**Development Review Board (DRB)
Review Comments
Utility Development Section
Reviewer: David G. Gutierrez, P.E.
Phone: 505.289.3381**

DRB Project No: PR-2018-001560	Date: 3/01/23	Item No: #2
Zone Atlas Page: E-20	Legal Description: Lot(s) TRACT A-2 PLAT OF TRACT A-1 AND A-2 HOFFMANTOWN BAPTIST CHURCH SITE, HOFFMANTOWN Location: HARPER ROAD NE between VENTURA STREET NE and WYOMING BLVD NE	
Request For: SD-2022-00172 – PRELIMINARY PLAT VA-2022-00332 – TEMPORARY DEFERRAL OF SIDEWALK SD-2022-00173 – VACATION OF PUBLIC EASEMENT – (30FT SANITARY SEWER) SD-2022-00174 – VACATION OF PUBLIC EASEMENT – (10FT WATER, SEWER, PUBLIC UTLITY) SD-2022-00175 – VACATION OF PRIVATE EASEMENT – (CROSS LOT BLANKET DRAINAGE EASEMENT)

DRB Project Number: 2018-001560 Hearing Date: 3/1/2023
 Project: Tract A-2, Hoffmantown Baptist Church Agenda Item No: 2

Project Name: Hoffmantown-Harper Rd.

**THE ESTATES AT ACADEMY  
HARPER CROSS SECTIONS**

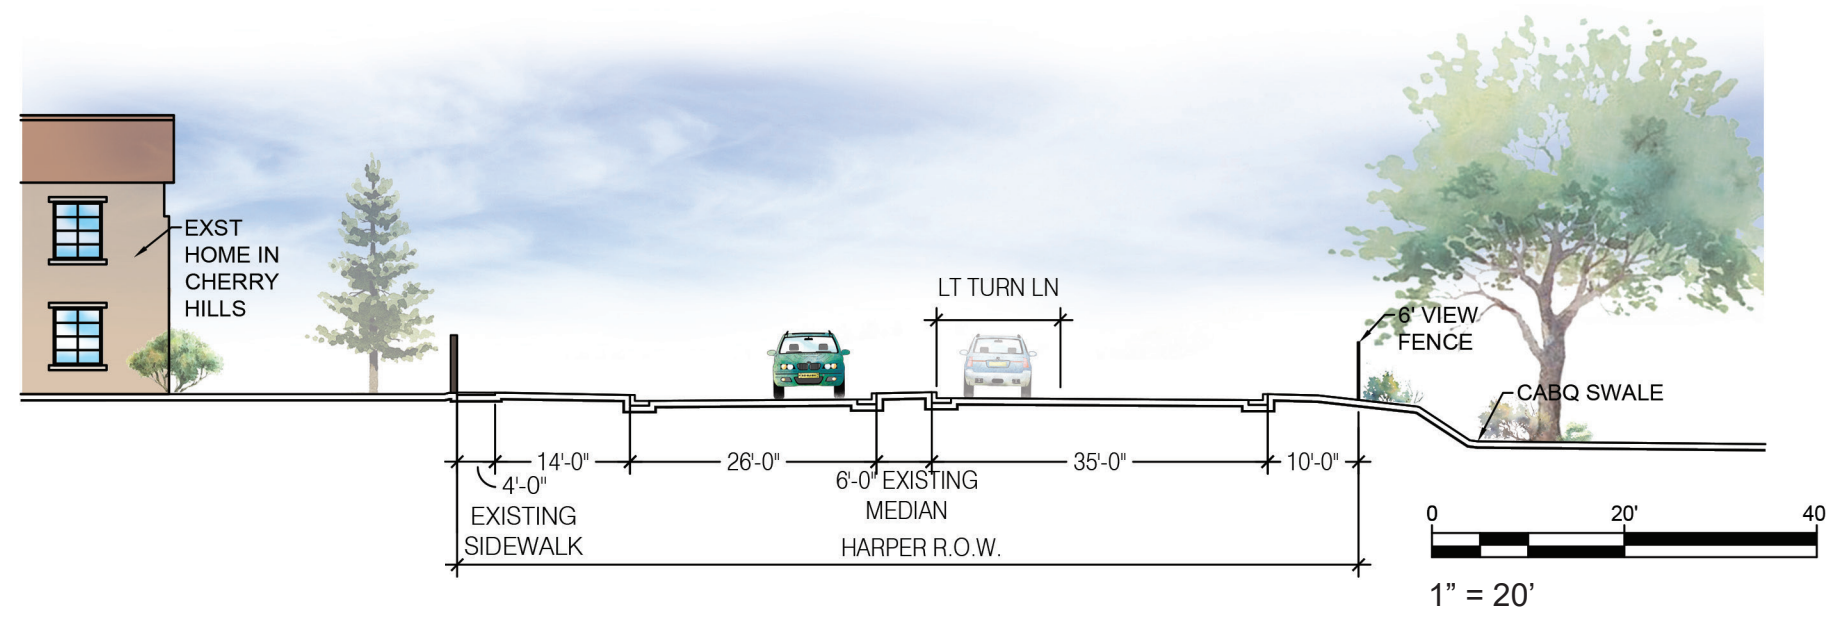
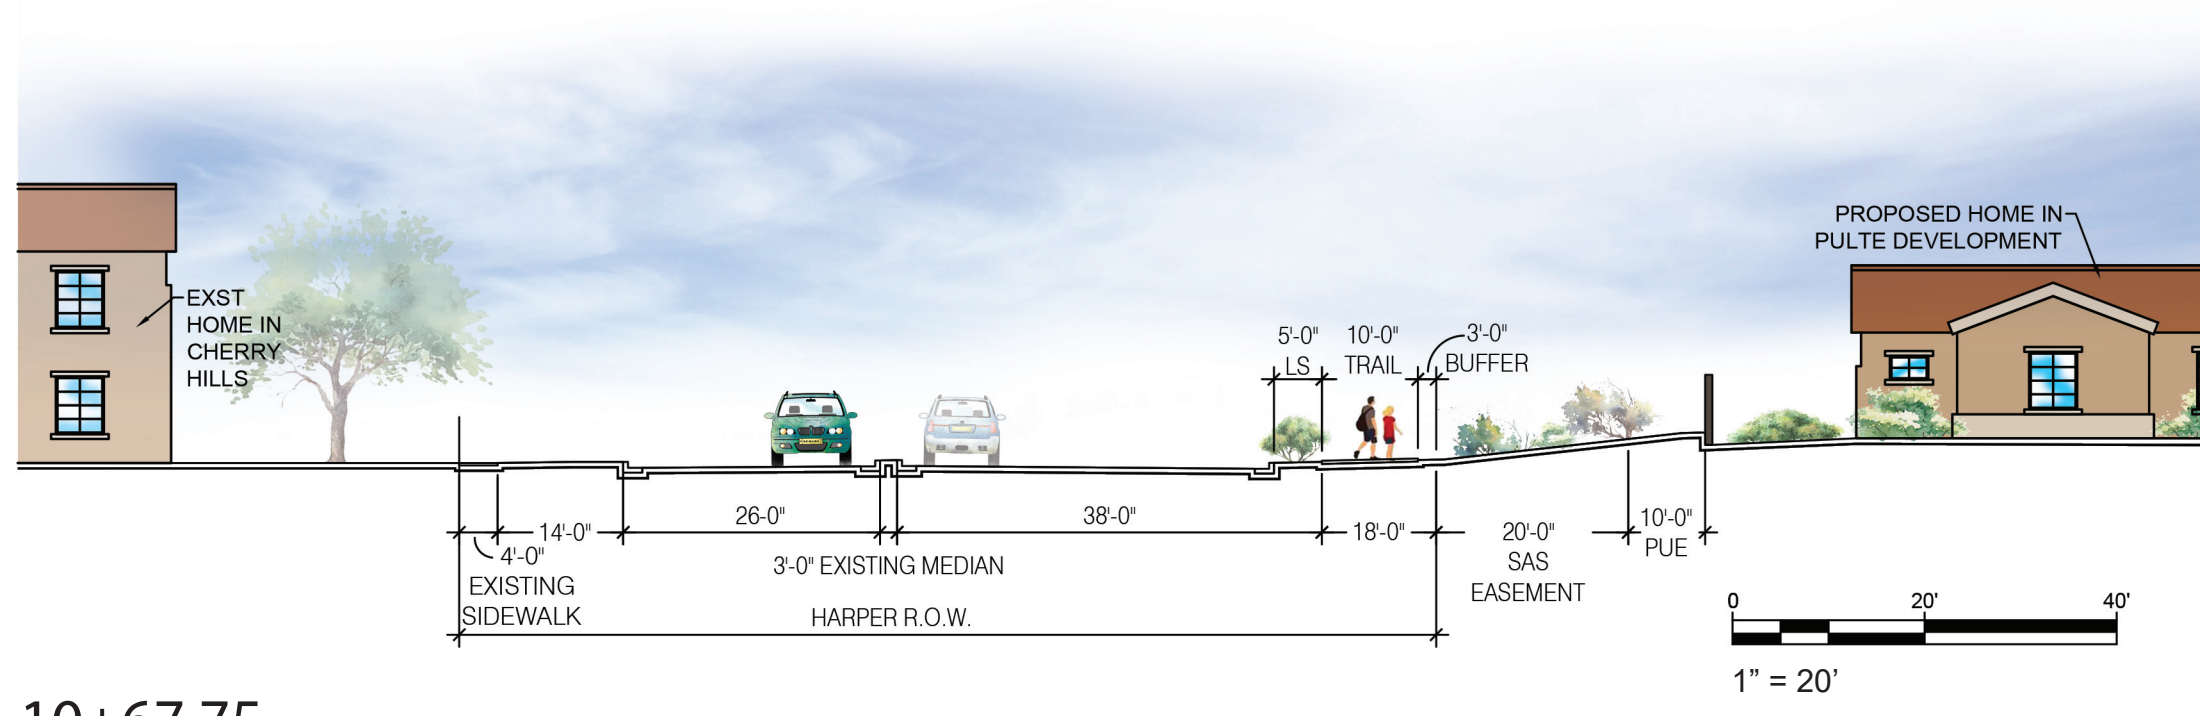
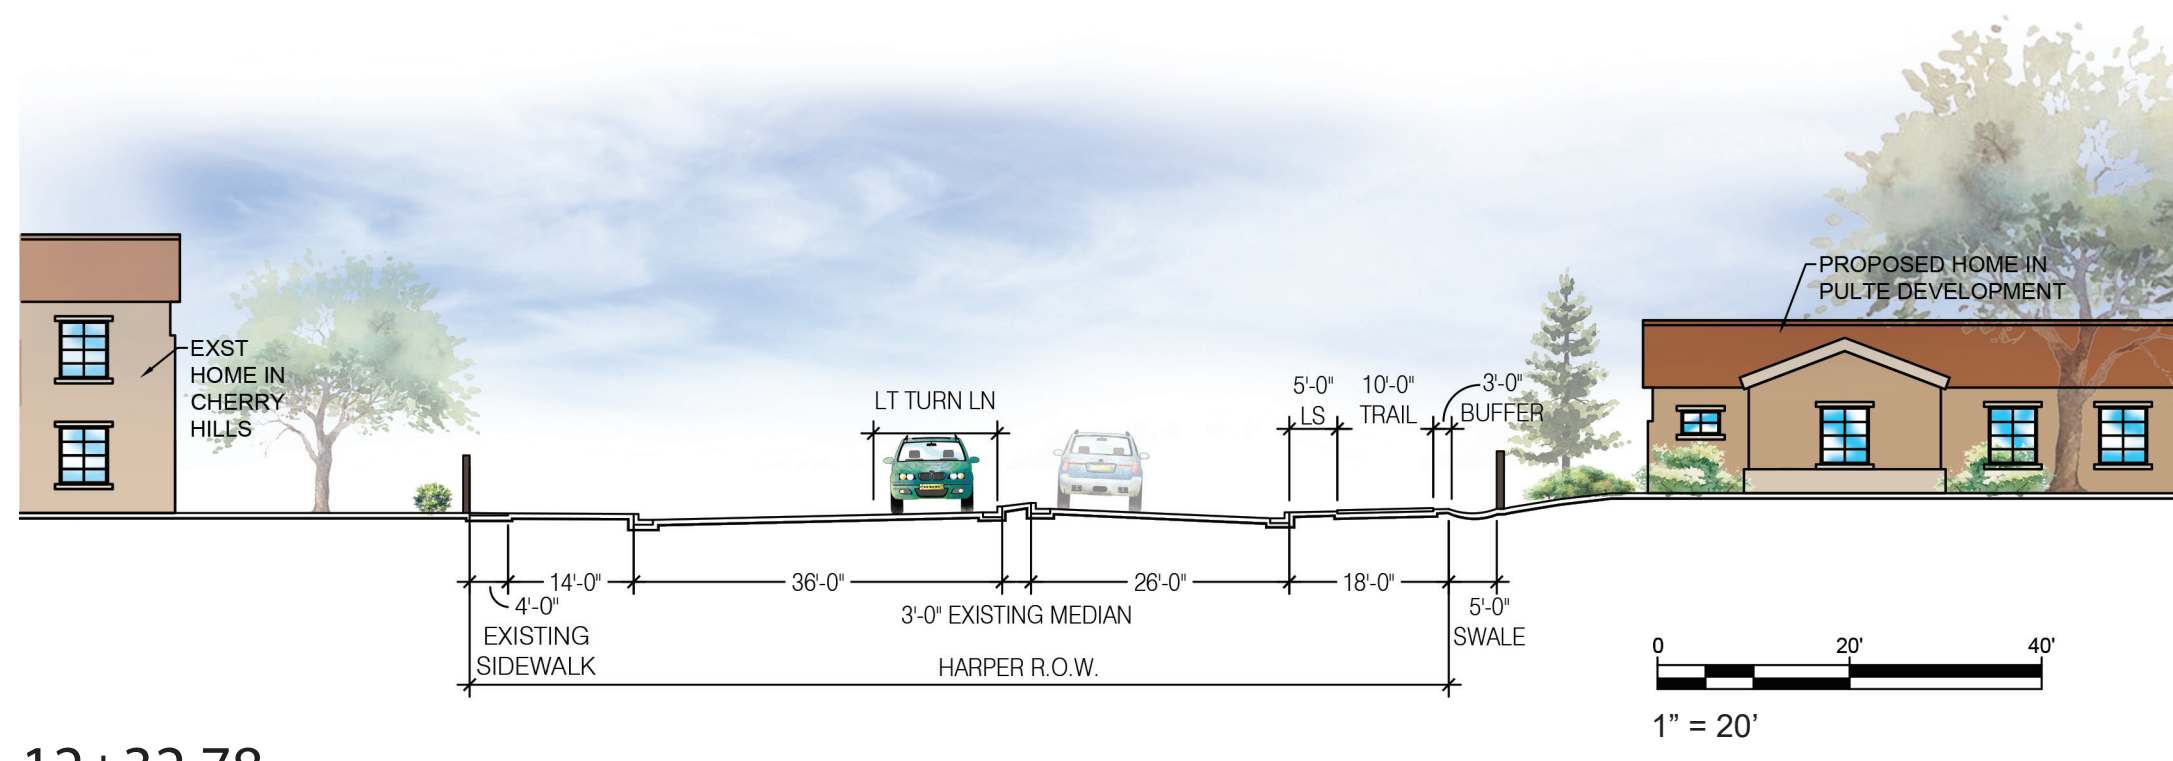
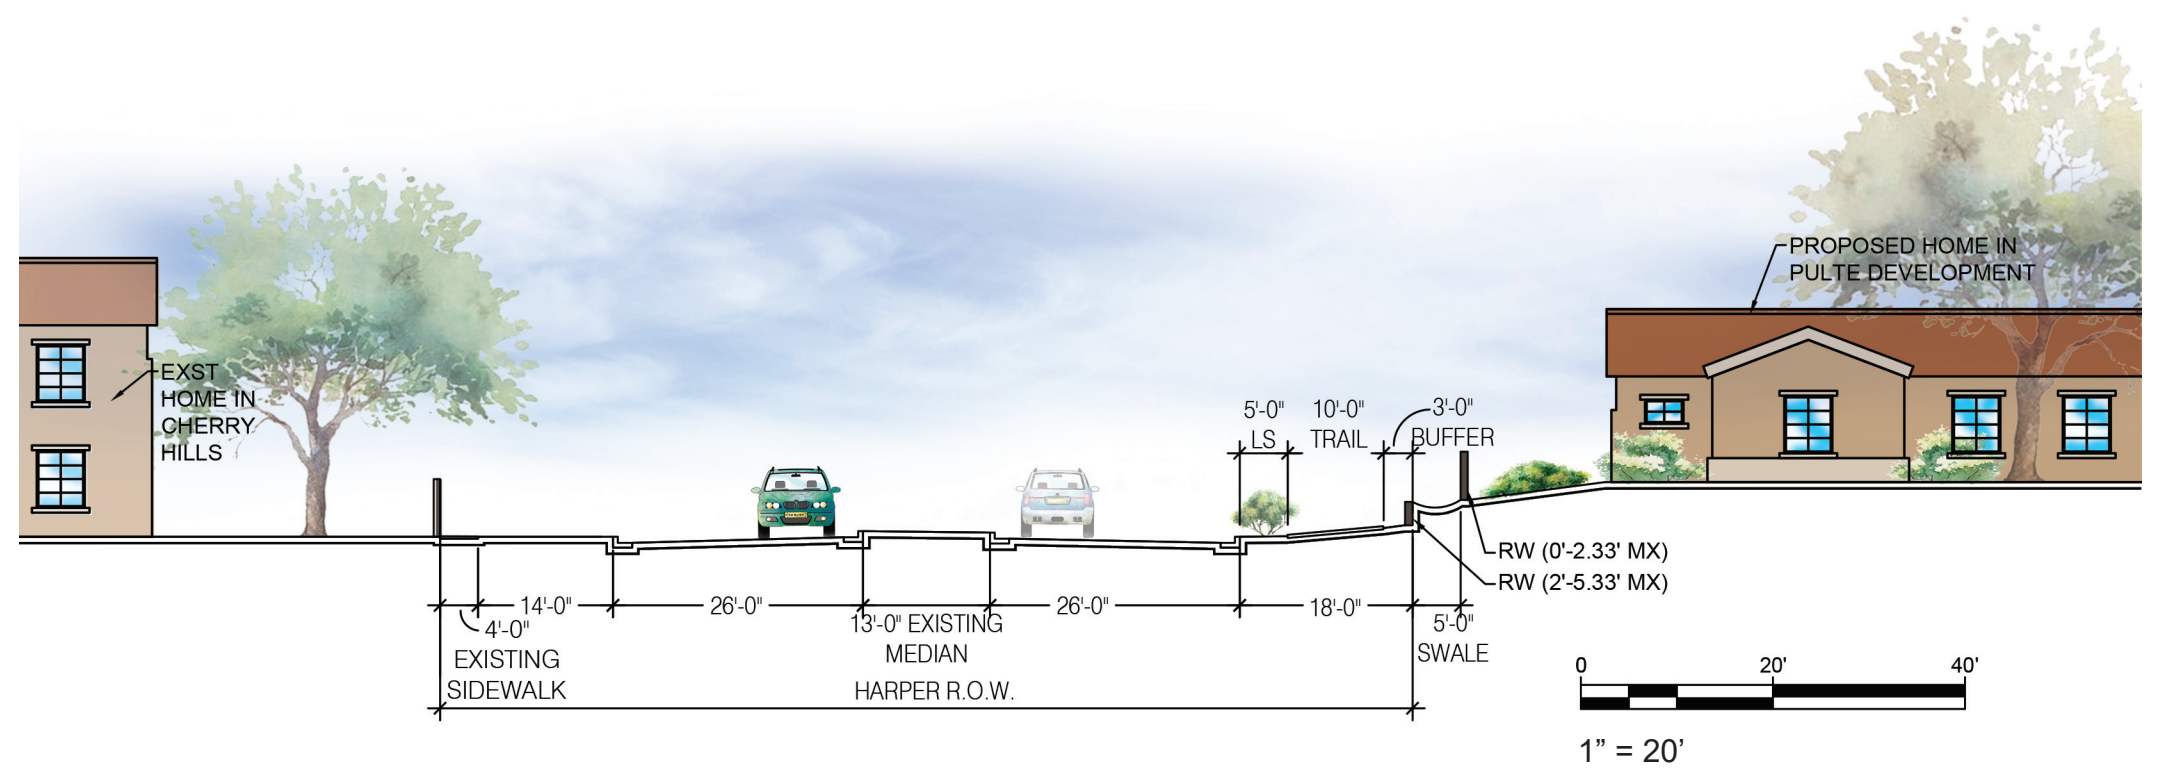
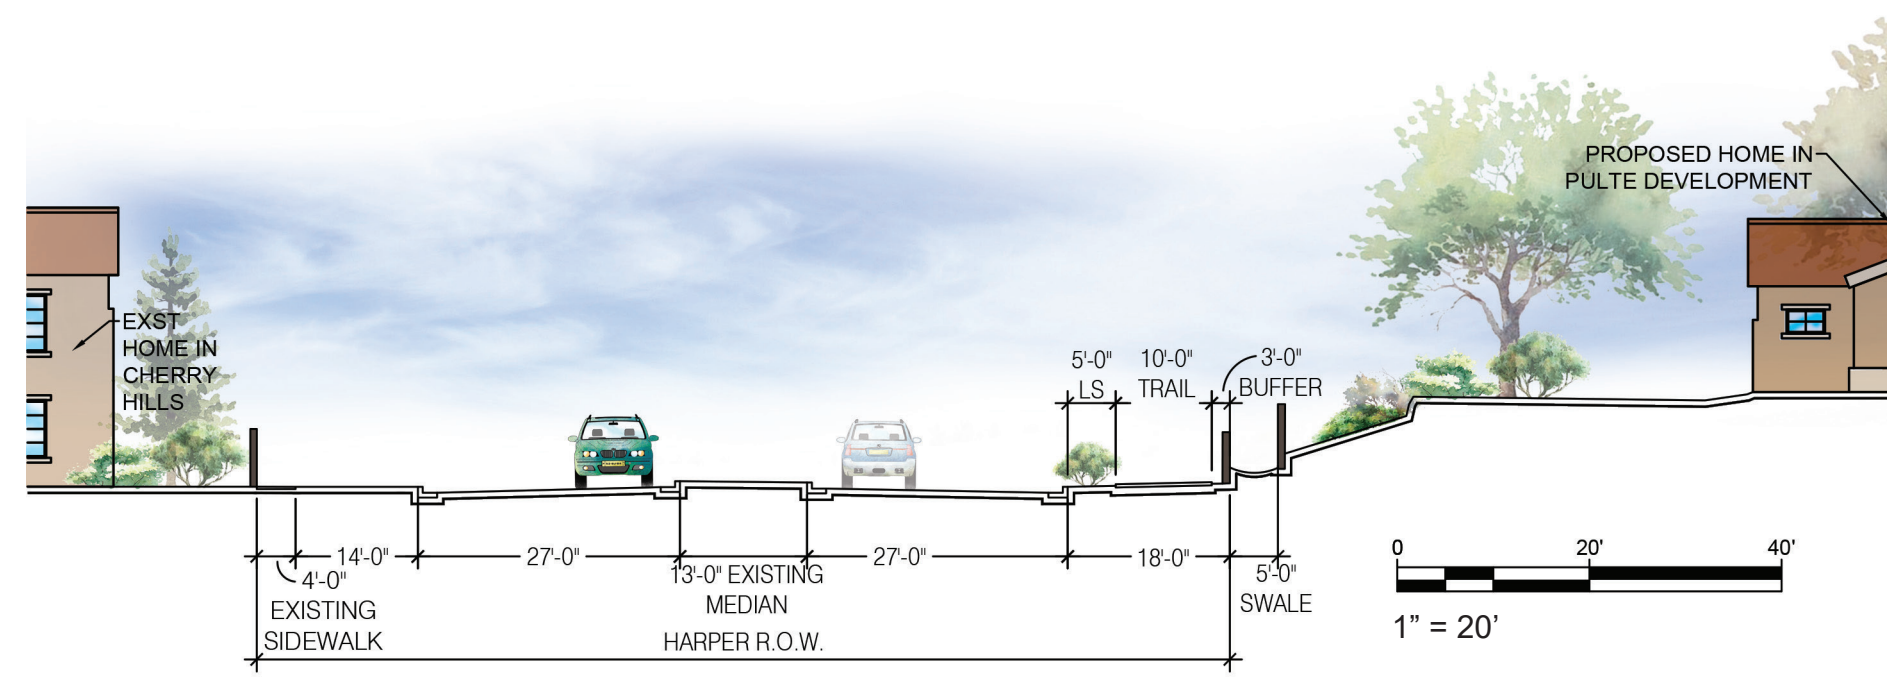
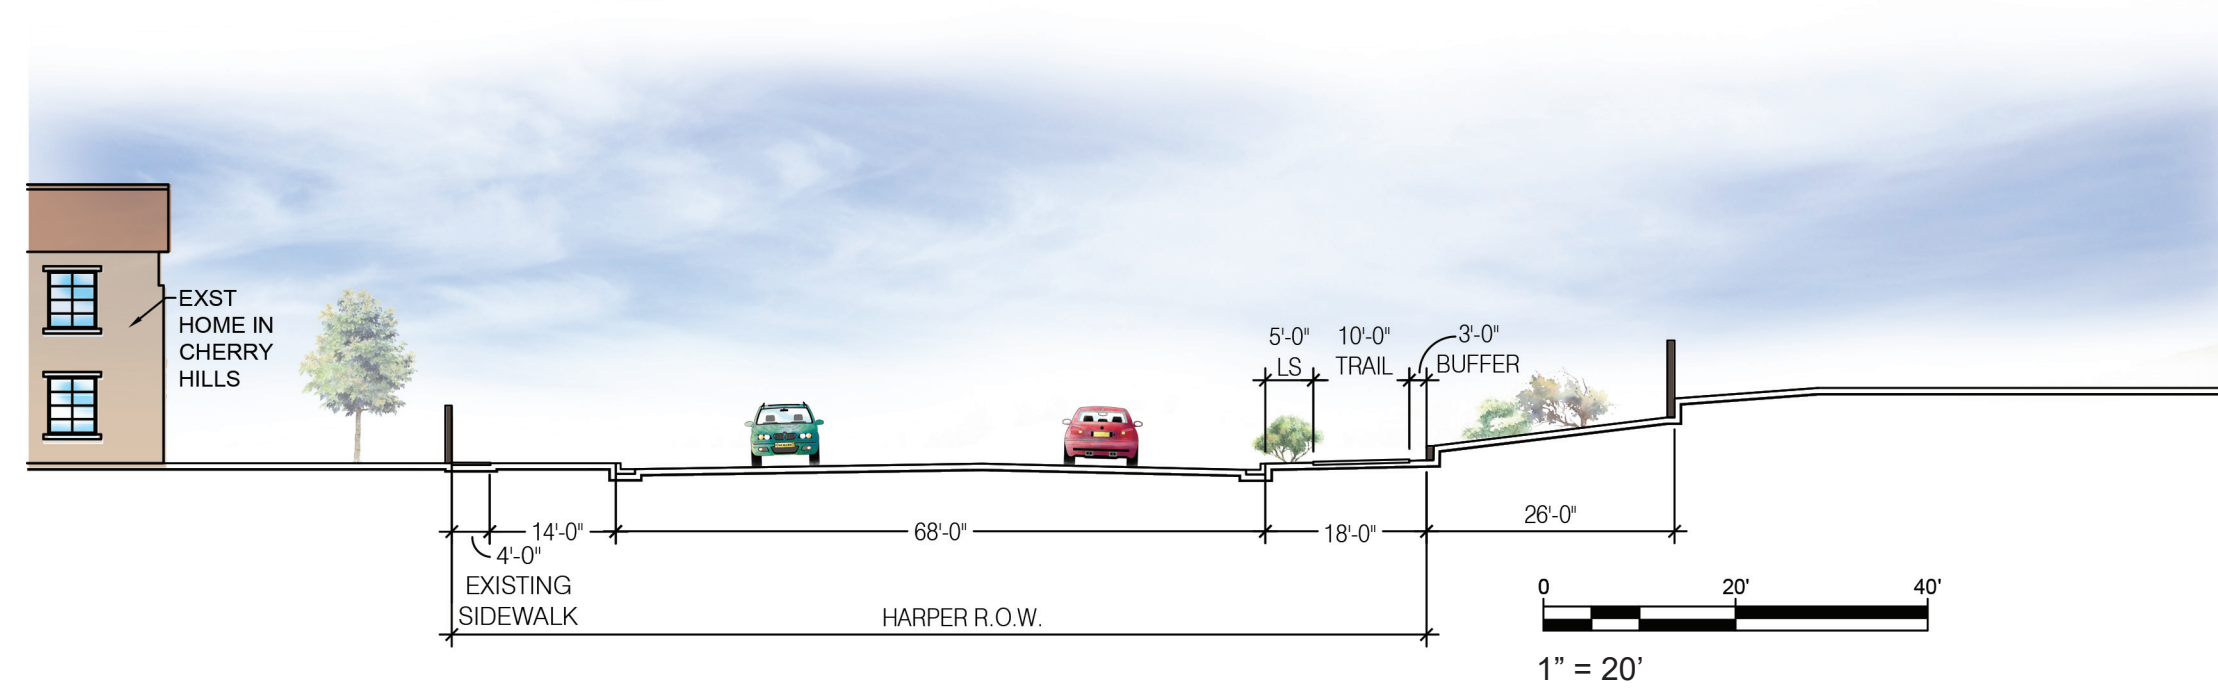
- On the Preliminary Plat, dedication of ROW is typically to City of Albuquerque Parks and Recreation Department for multi-purpose trail (existing could be confused with DMD).
- On the sidewalk exhibit, please show the asphalt multi-use trail as a different color to show the location and extent rather than sidewalk.
- Can the trail extend along one side of the entry where the sidewalk is deferred (Section B-B)?
- On the Infrastructure List, the multi-use trail may need to specify “asphalt”.
